Application No: AL/47/20/HH
Site Address: 12 Lime Avenue Aldingbourne PO20 3UF
Description of works: Removal of existing garden fence and reinstatement of same on western boundary of the property.

Aldingbourne Parish Council objects to this application on the basis that:

12 Lime Avenue - PROPOSED FENCE LINE
MARKED IN RED.

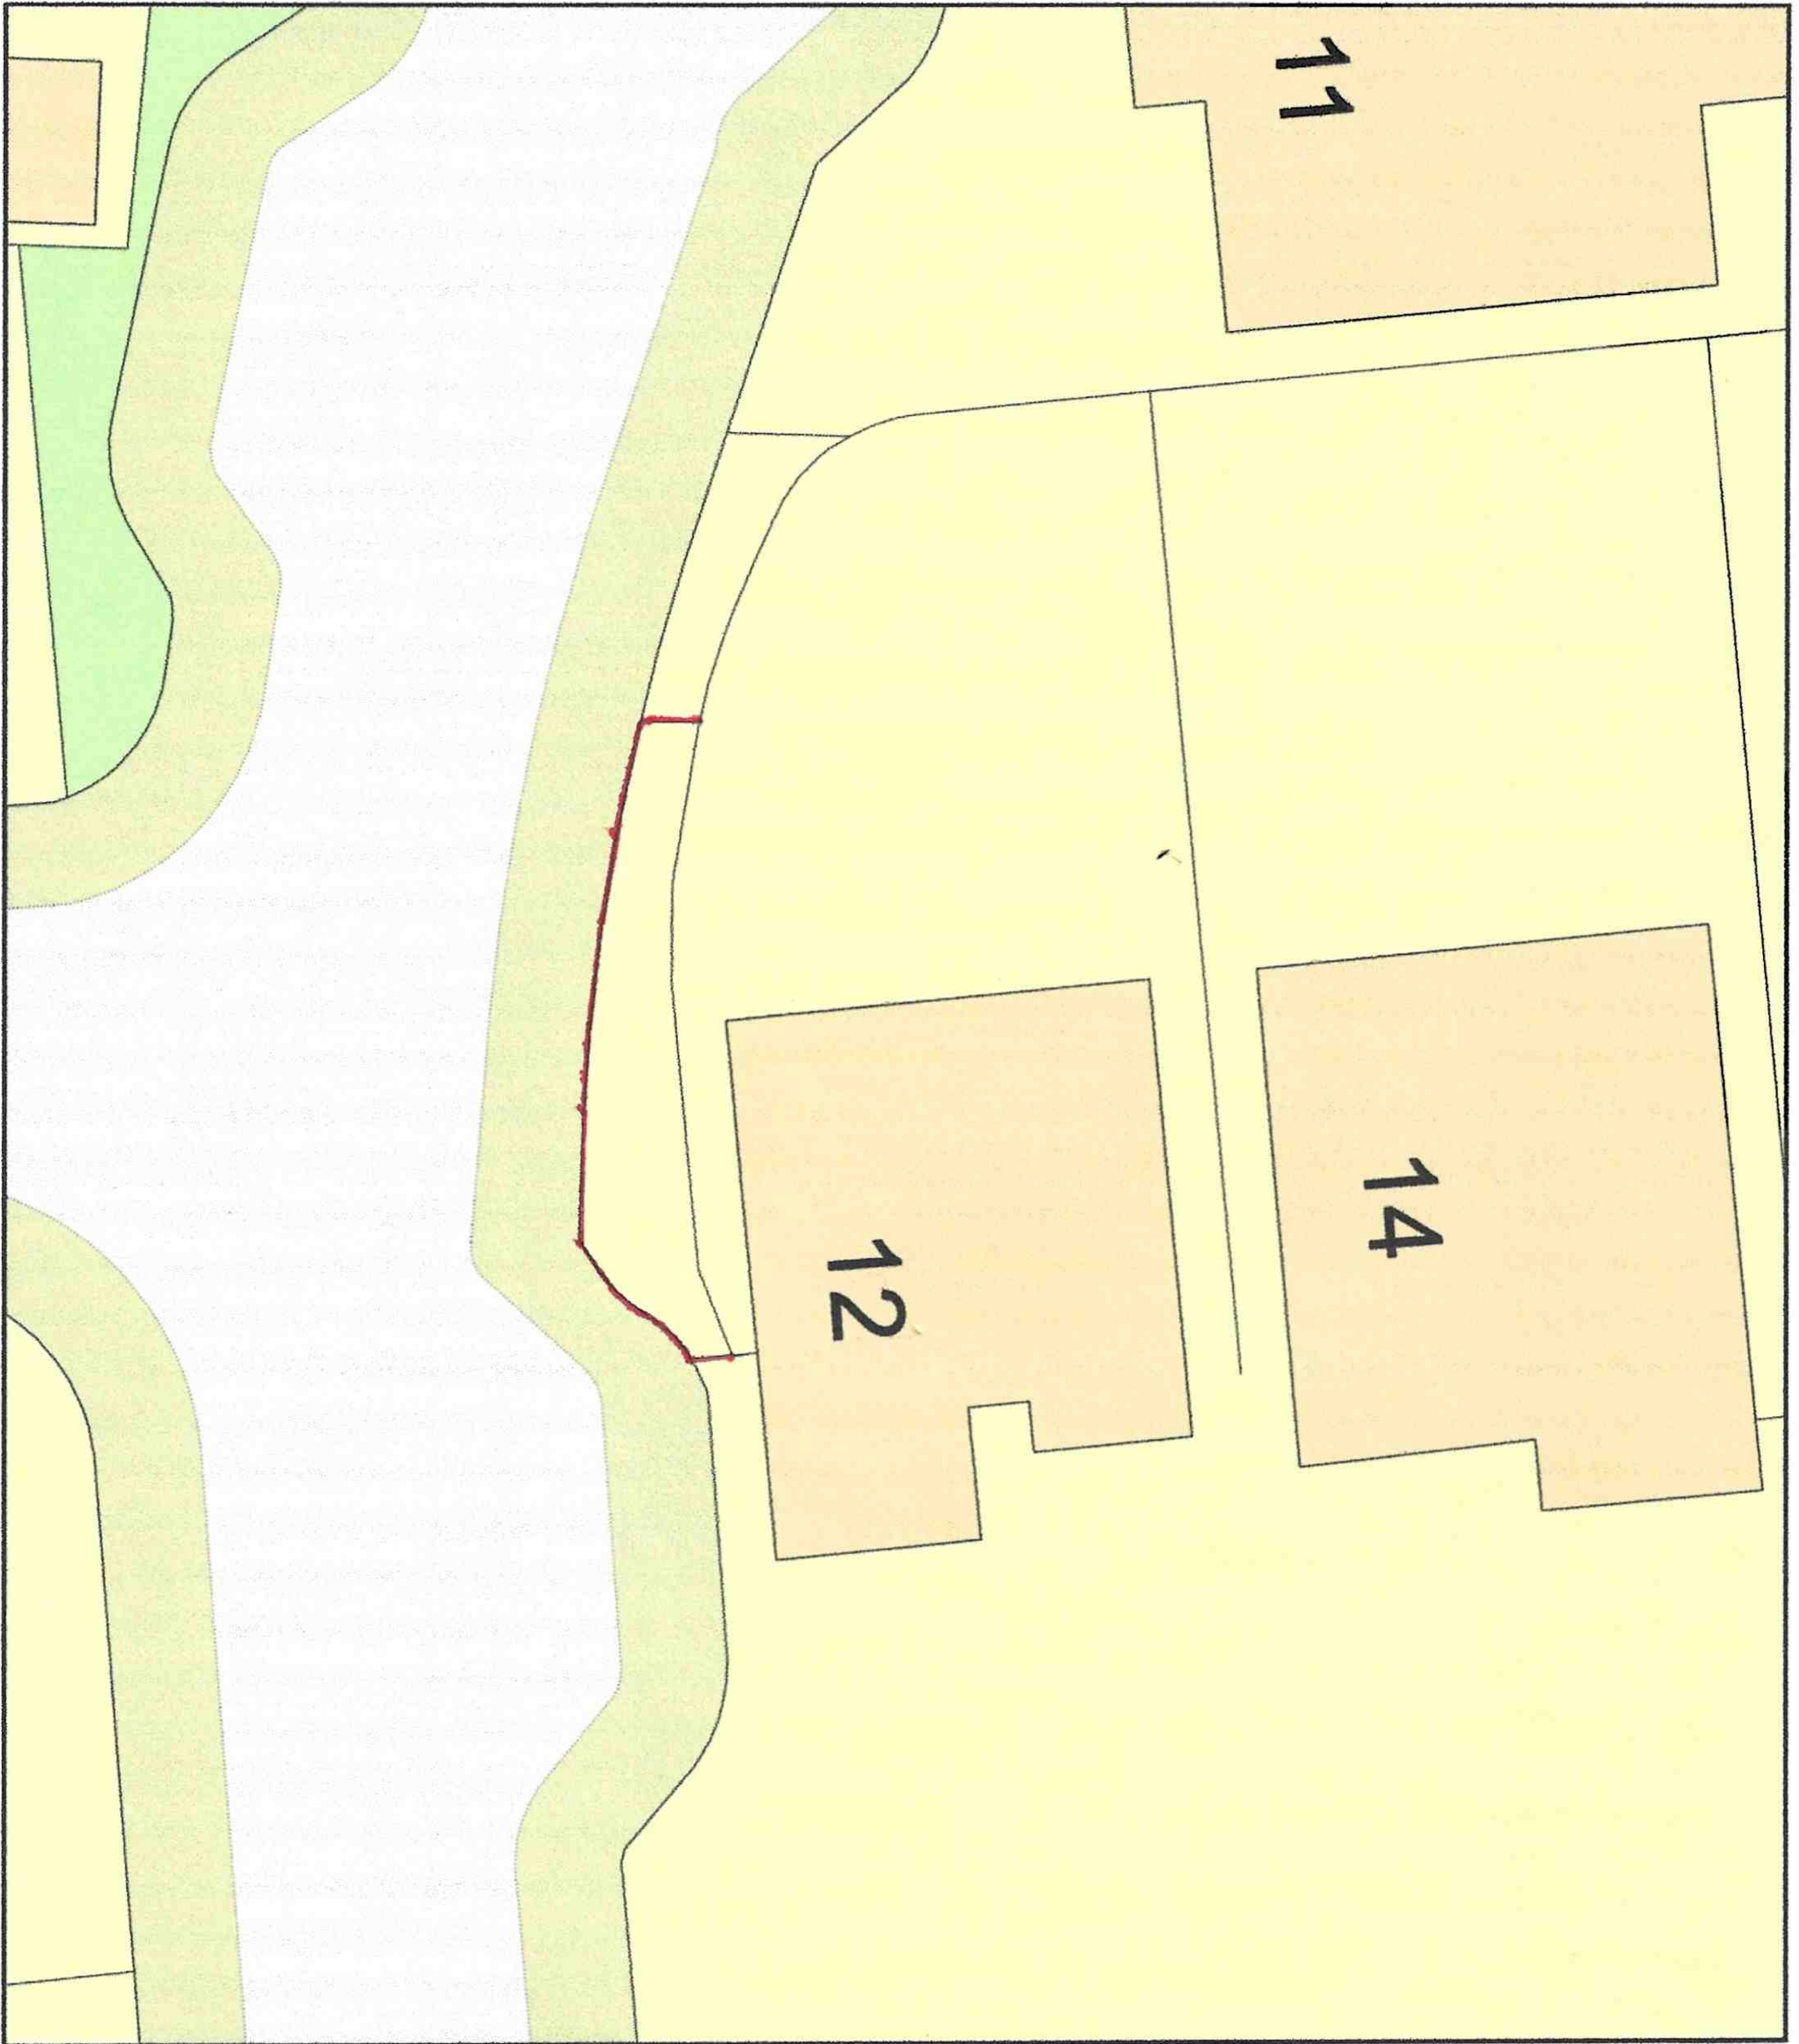
- the design is not sympathetic to Aldingbourne's Neighbourhood Plan's Design guideline EH9, and
- the proposal does nothing to enhance the overall landscaping that would have been agreed originally under the planning process for the whole estate.

In addition, this authority highlight's the need to verify ownership of the boundary of the land which this application relates to.
